**From:** Cllr Harry McCarthy  
**Sent:** 10 March 2026 23:48  
**To:** Jillian Rann; DC Admin  
**Cc:** Cllr Beverley Addy; Cllr Matthew McLoughlin  
**Subject:** Re: Land at former Clough Mill, Clough Road, Slaithwaite (Application 2025/93543)

I am writing with regard to planning application 2025/93543 for the erection of 33 dwellings at the former Clough Mill, Clough Road, Slaithwaite, HD7 5DB.

Proposed Layout
Design Review

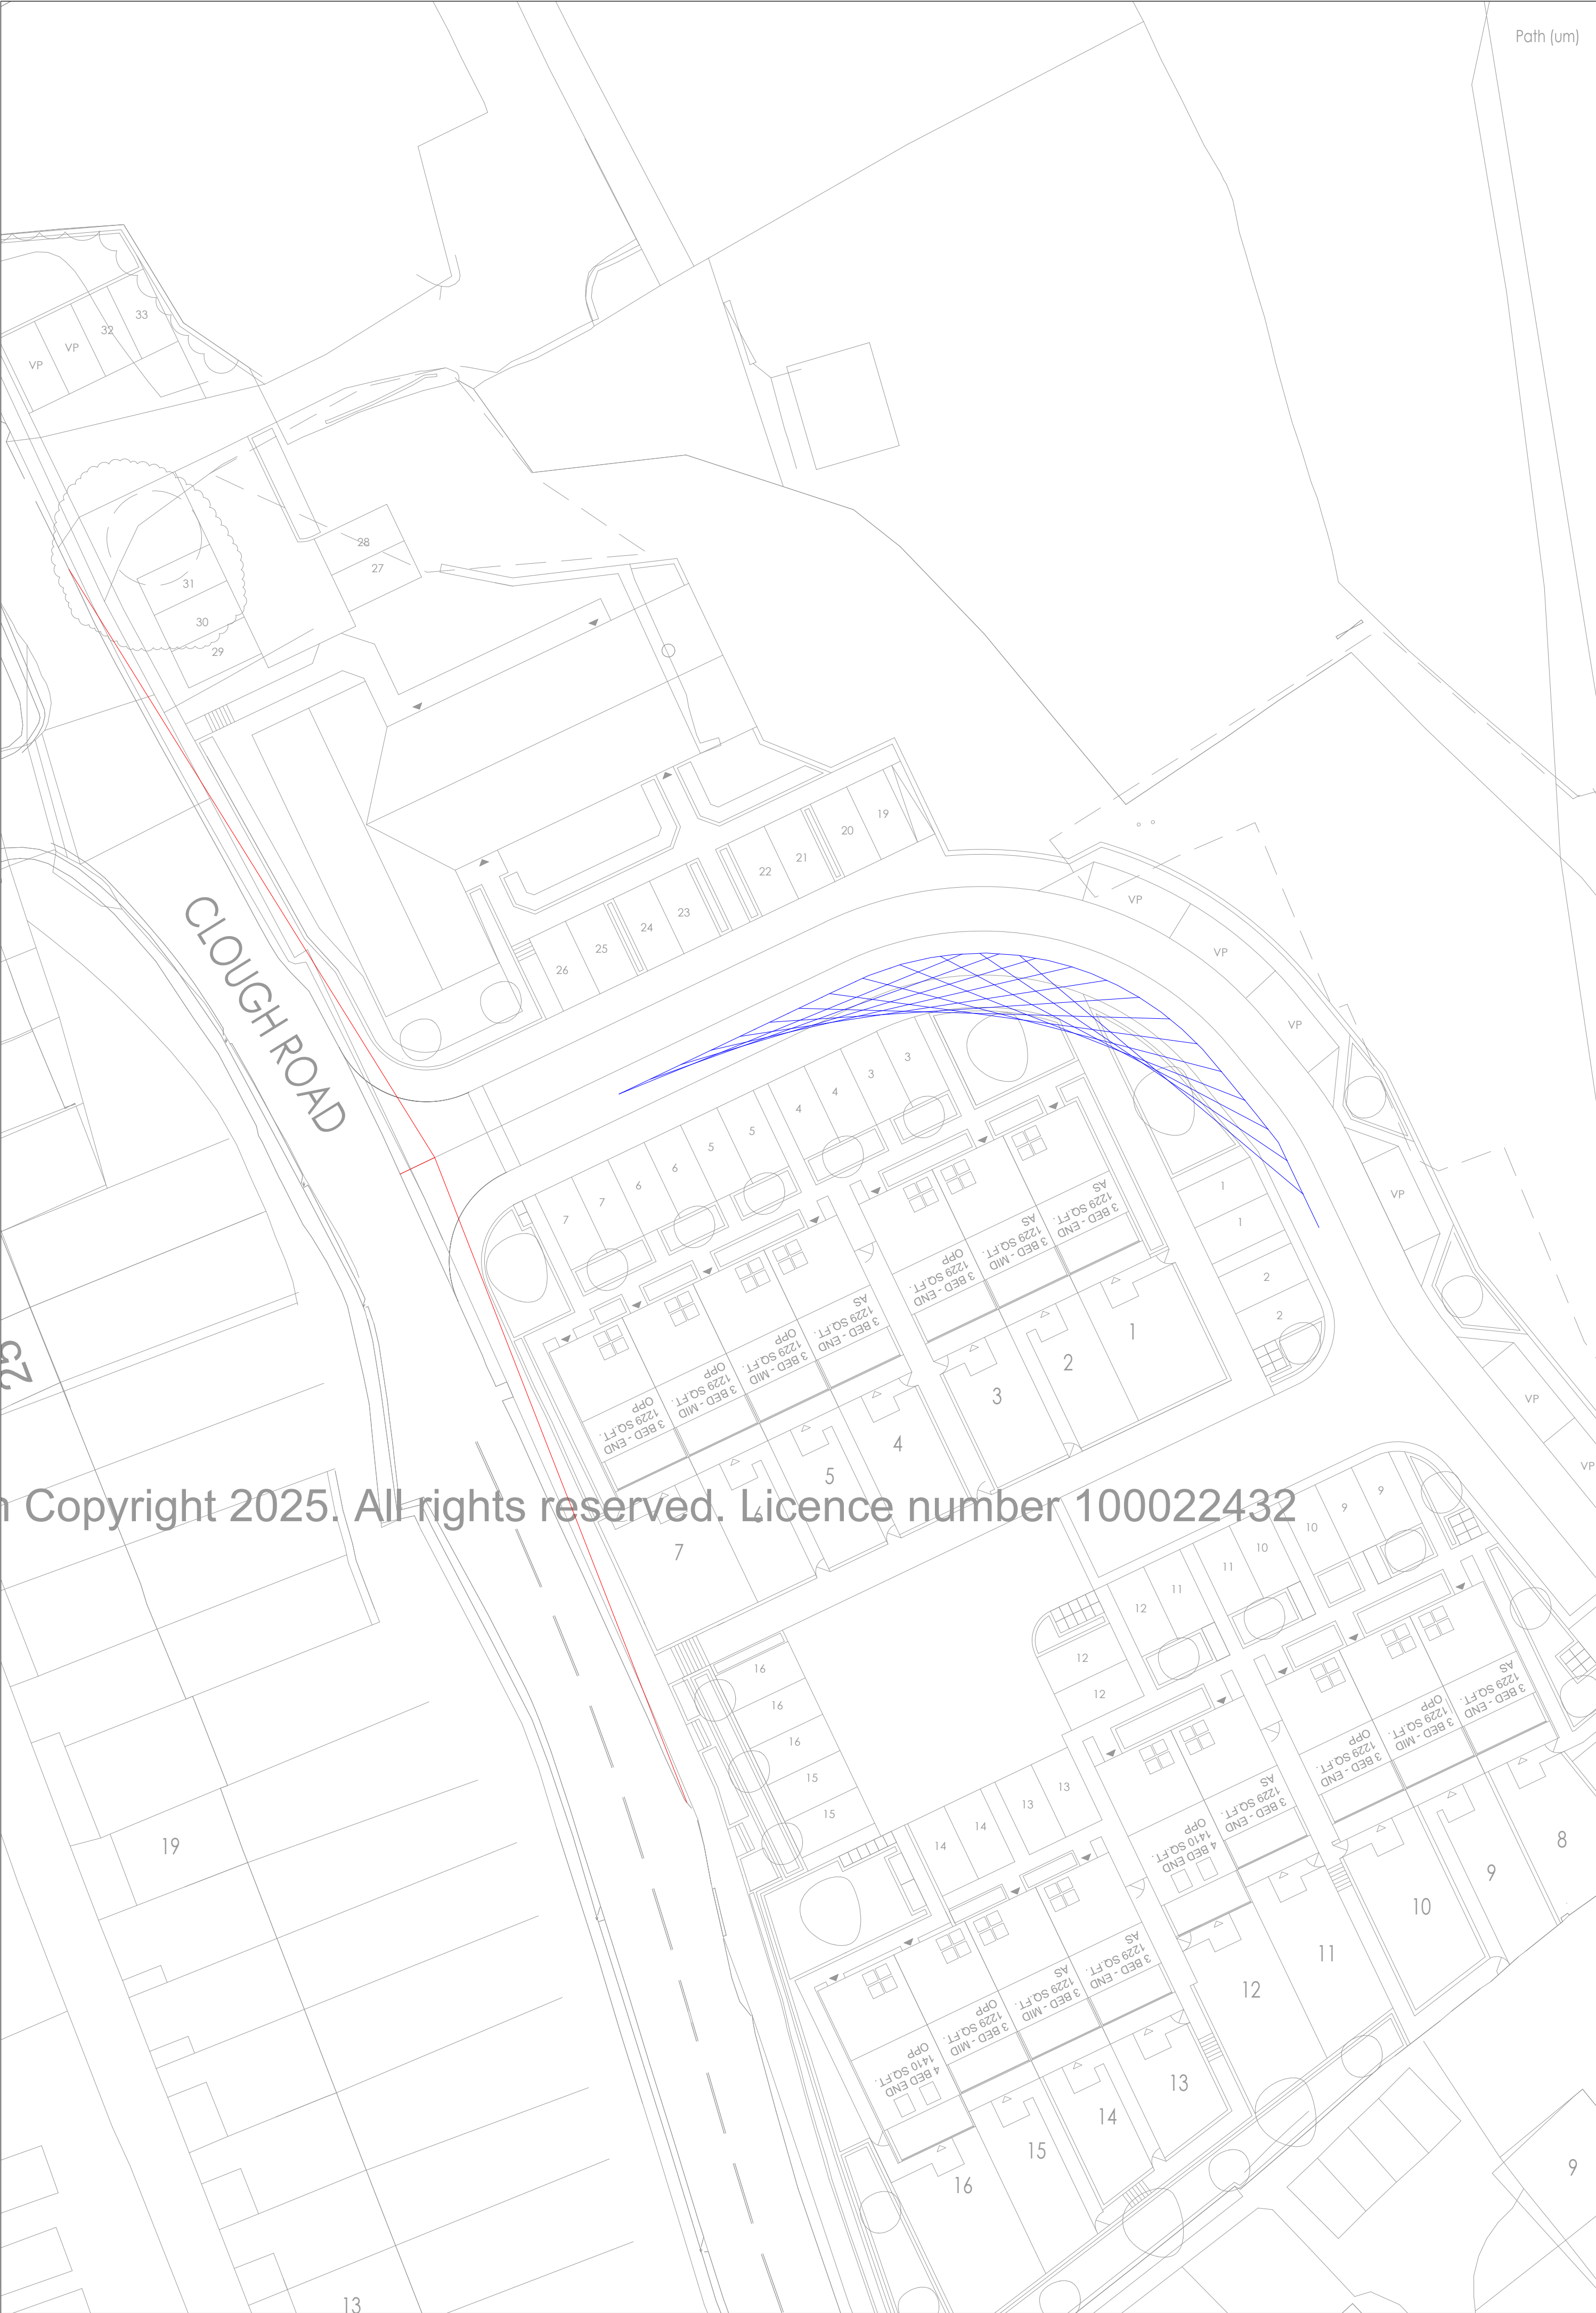
The proposed access point for the development is at a narrow section of Clough Road. This should be reviewed on highways safety grounds.

A traffic regulation order to restrict parking on Clough Road near the development should be considered to deter problem parking.
